Re: **Marysville Corporate Center – BSP (PA22004)**
3rd Round Response Letter
Project Number 2200444.00

In response to your plan review checklist dated January 10, 2023, we have addressed the items below, with our responses following your comments.

PARKING COMPLIANCE – BLDG 207

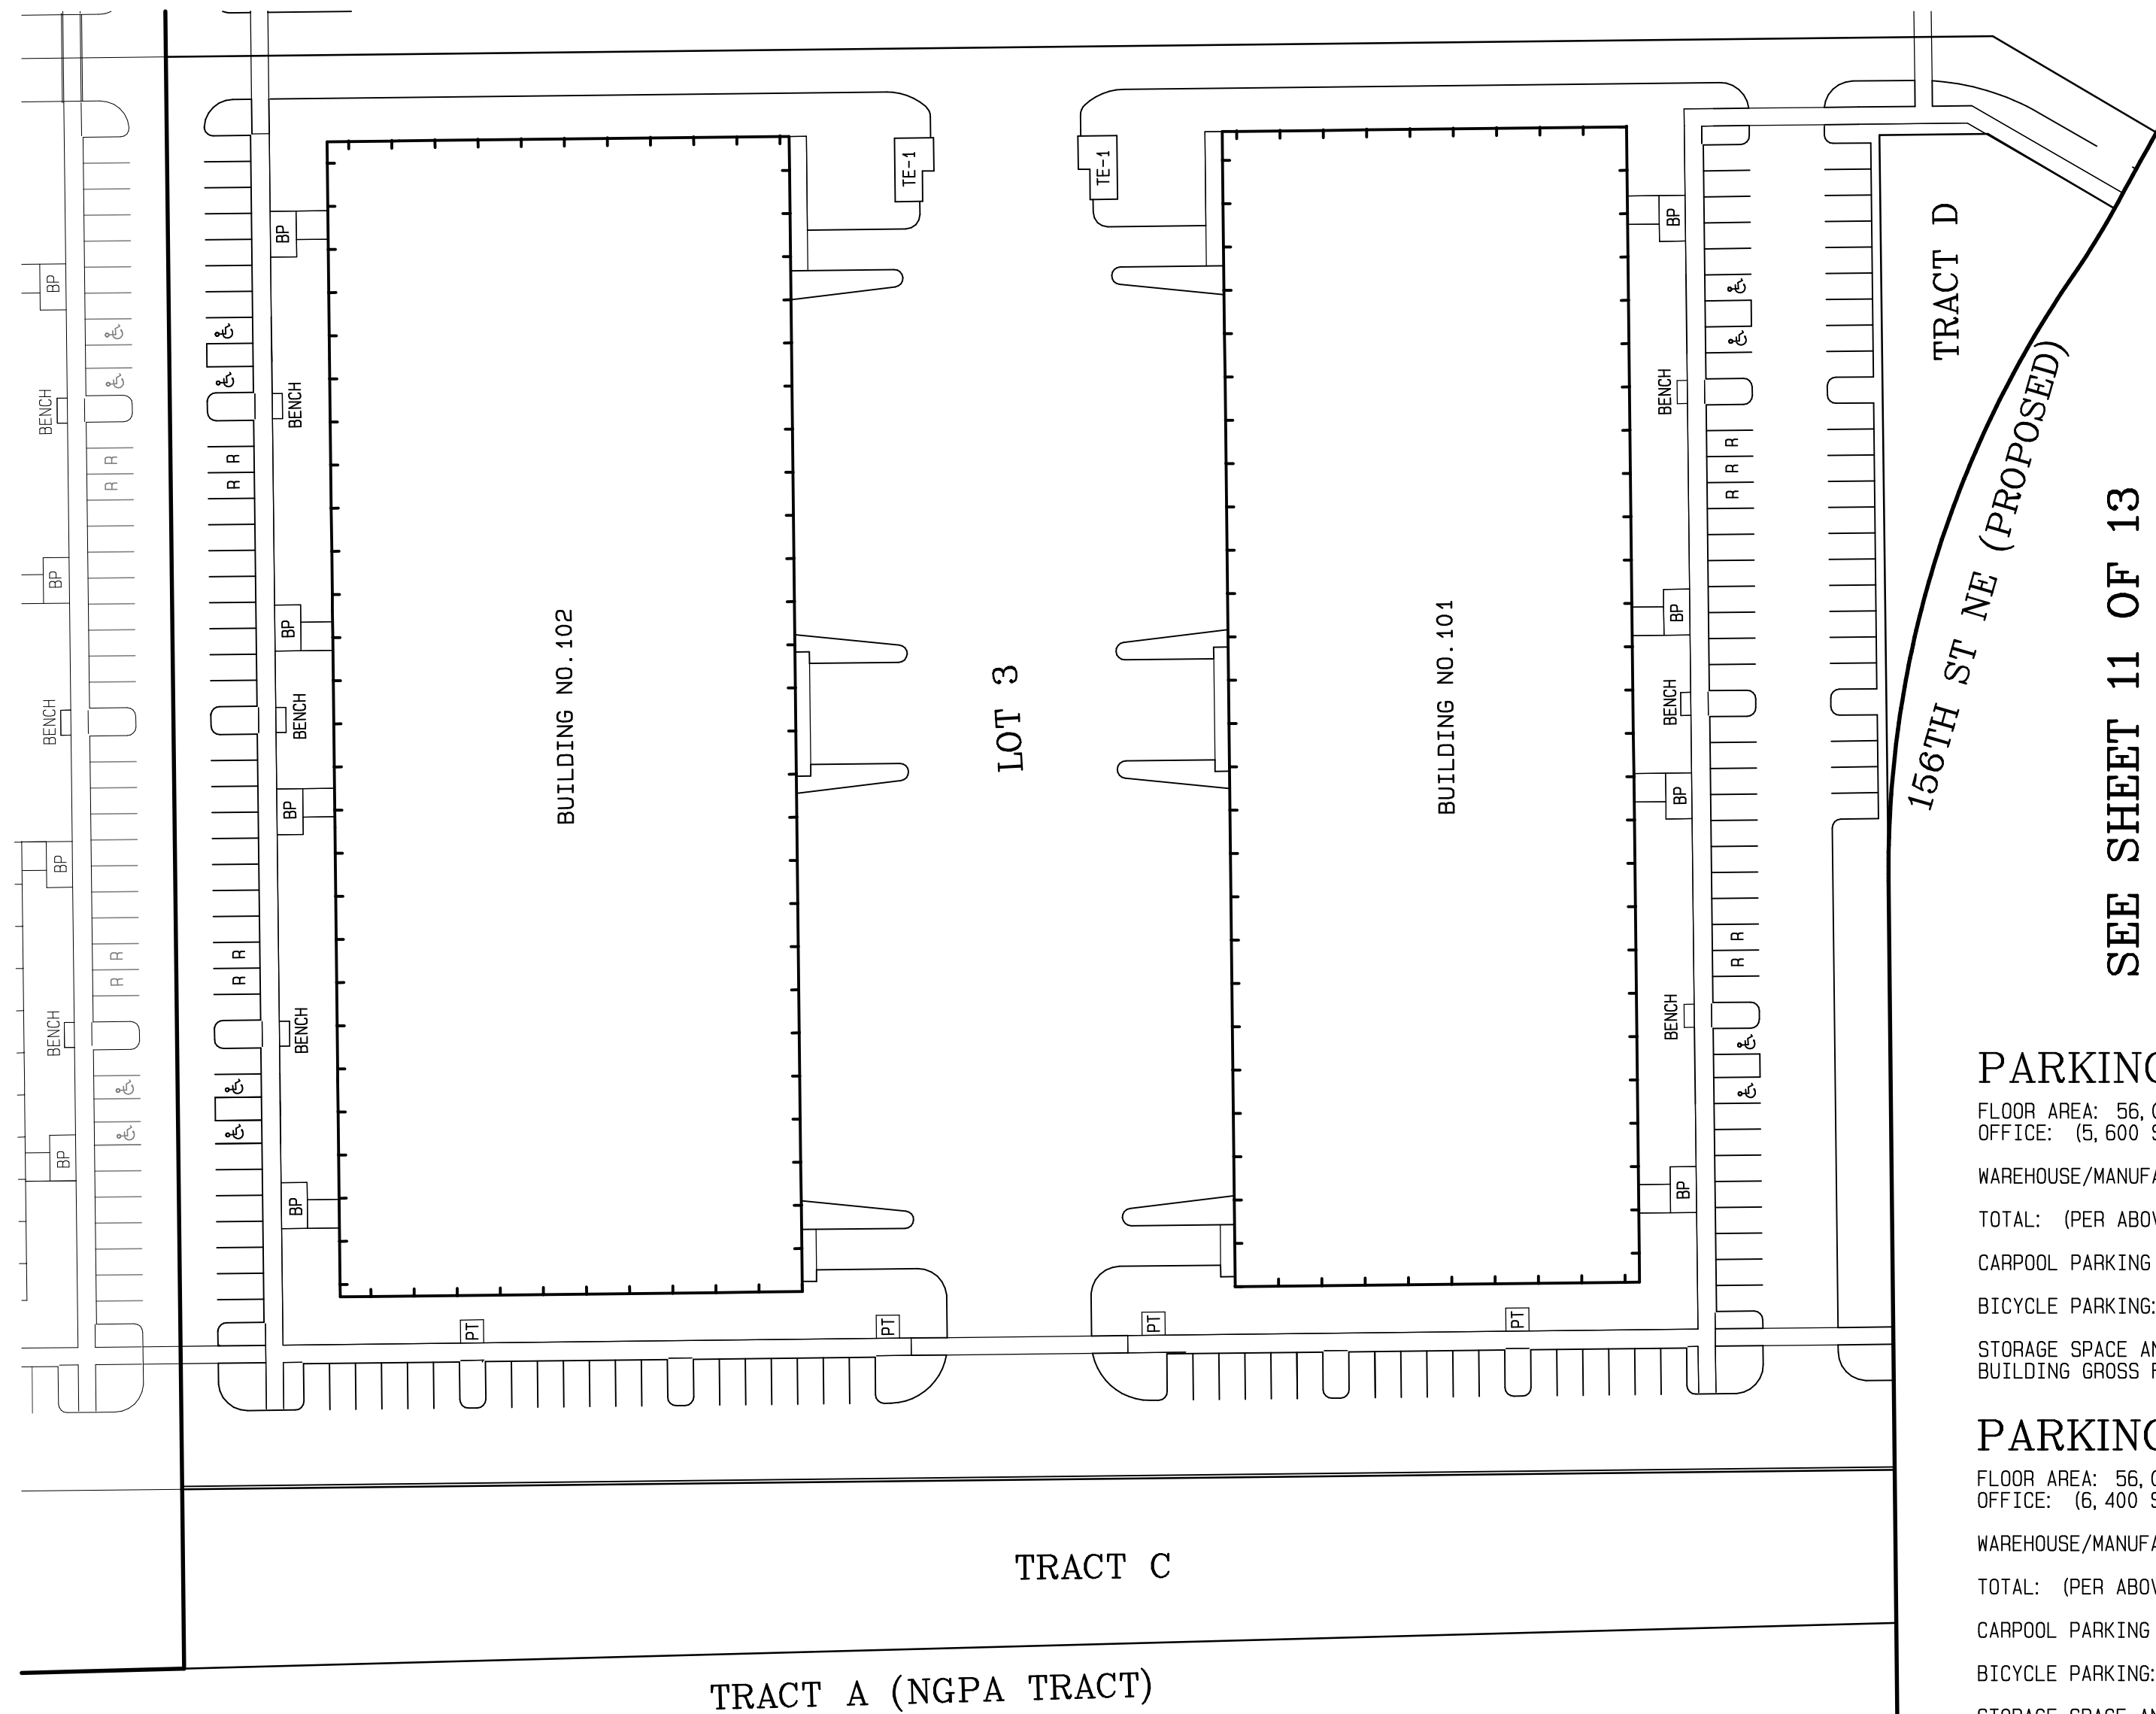
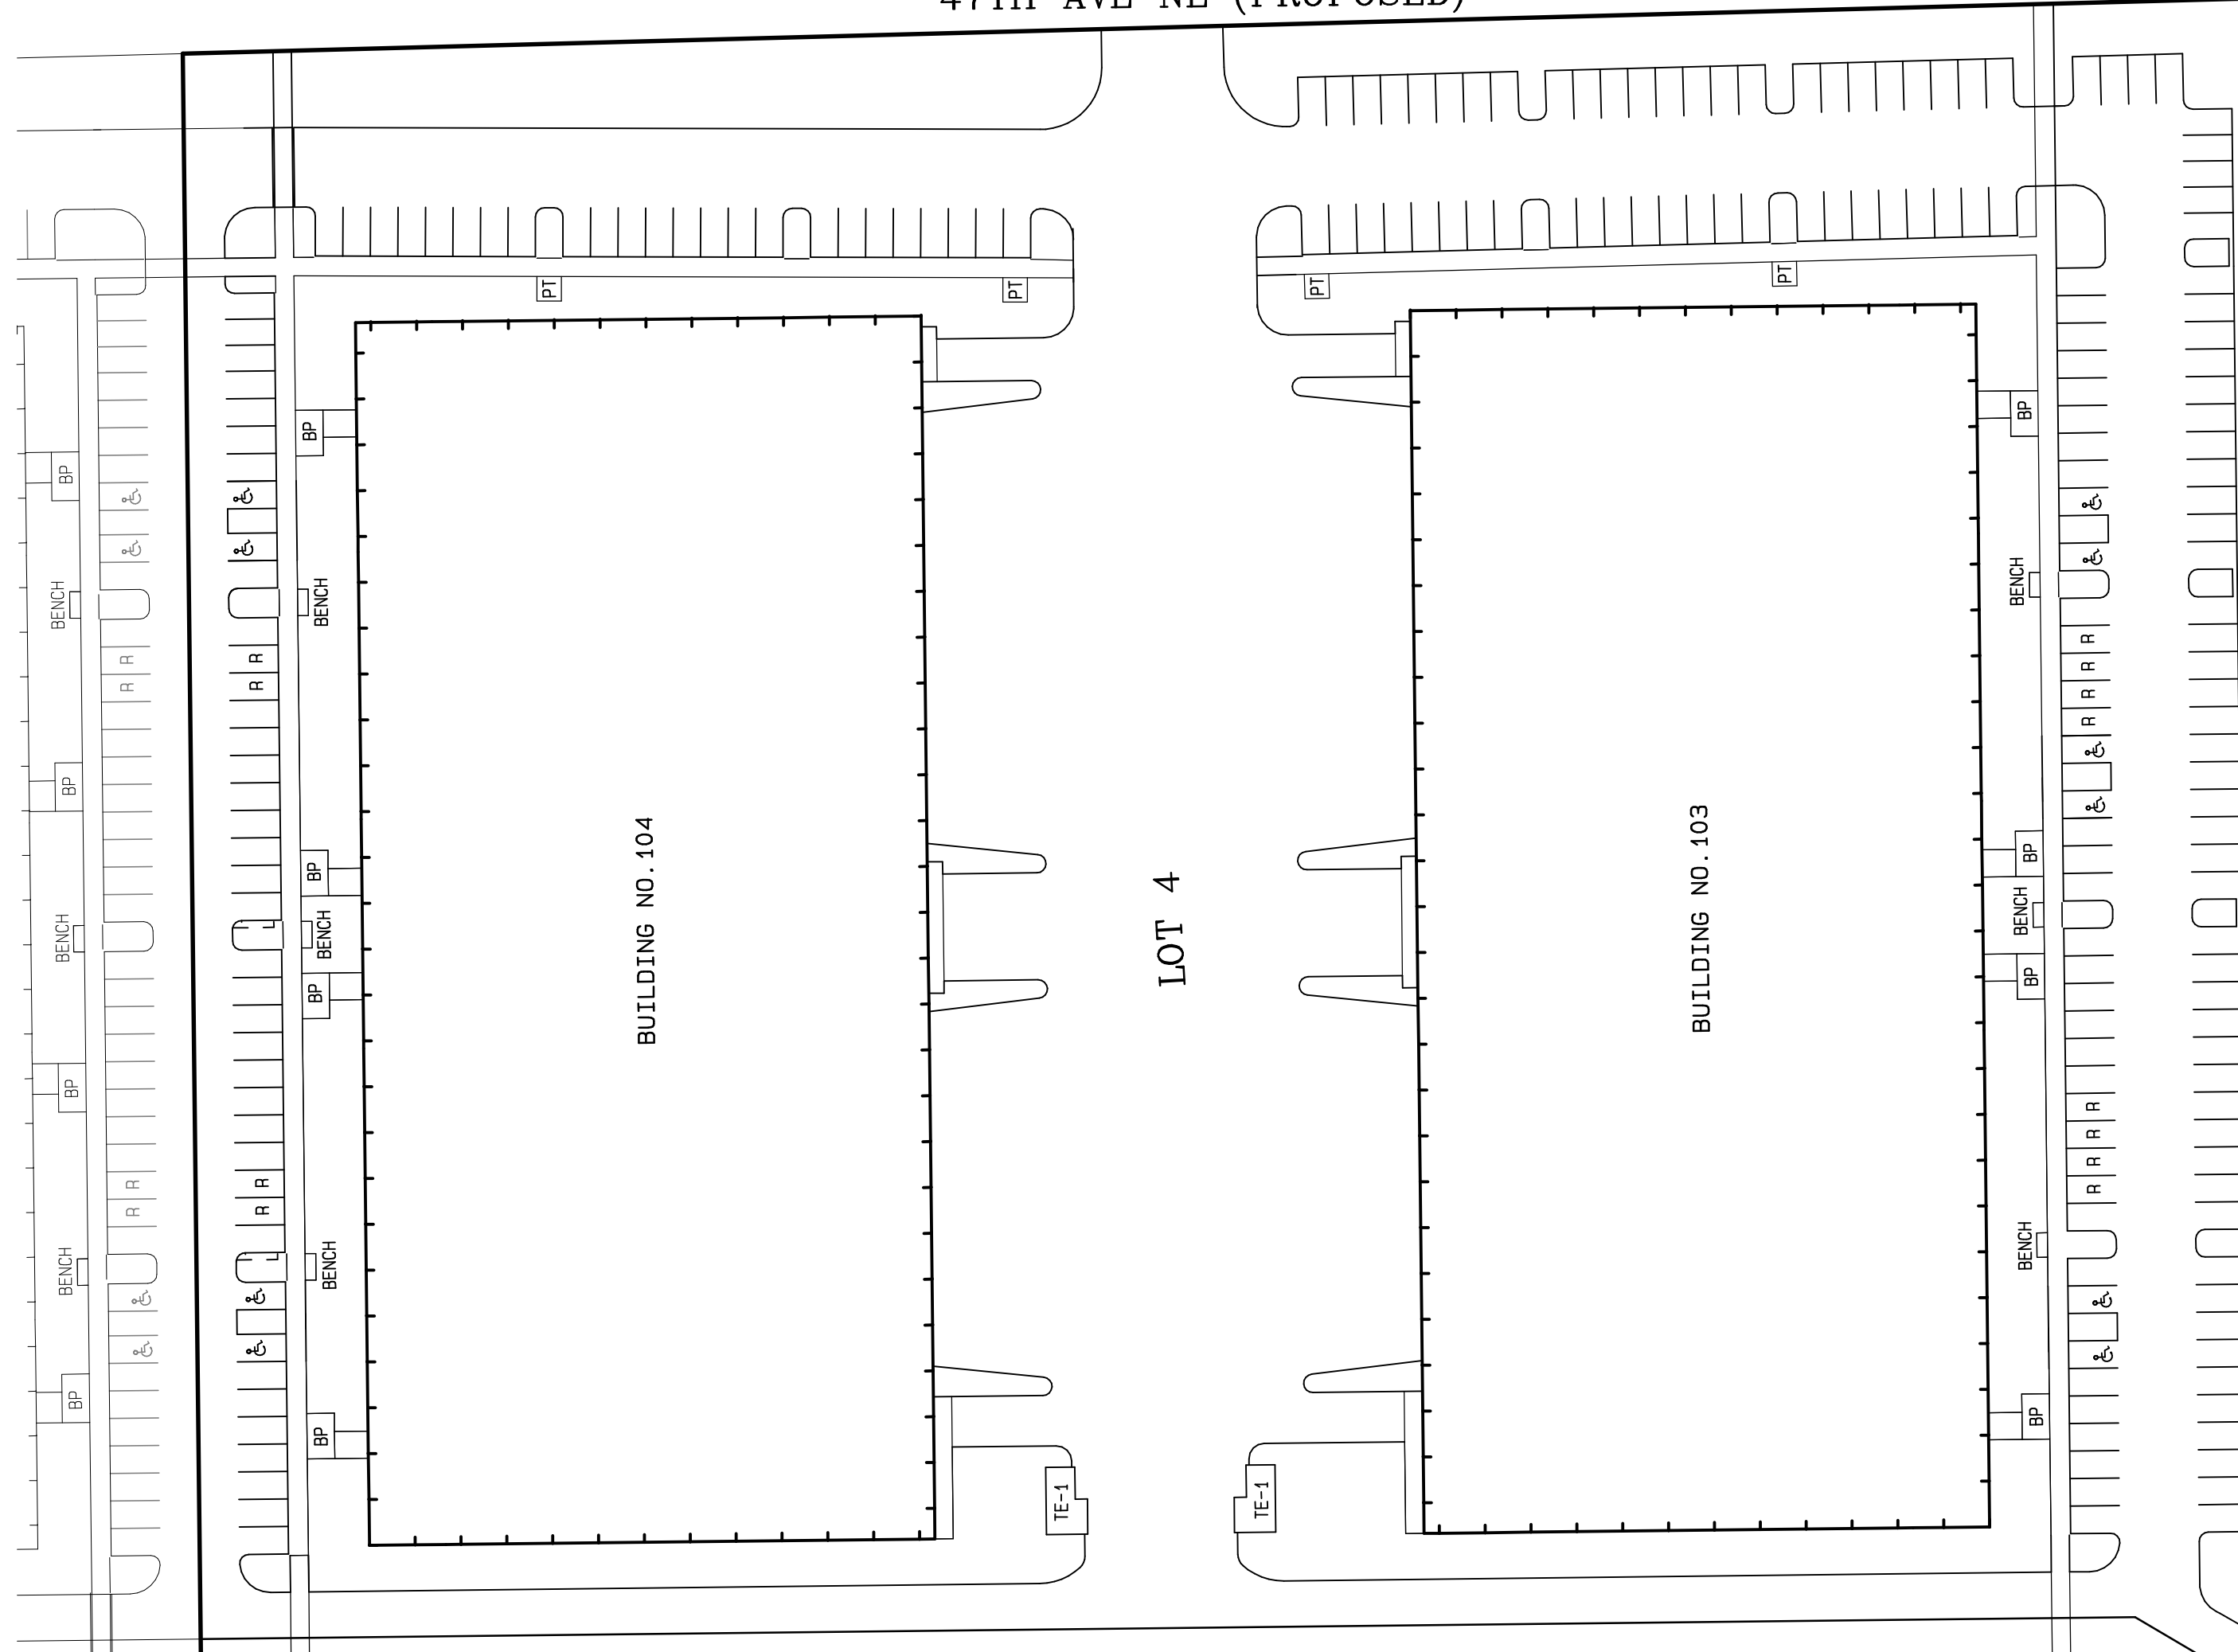
6. *Provide ADA parking calculations and locations.*

Response: ADA parking calculations and locations are shown on each respective BSP sheet.
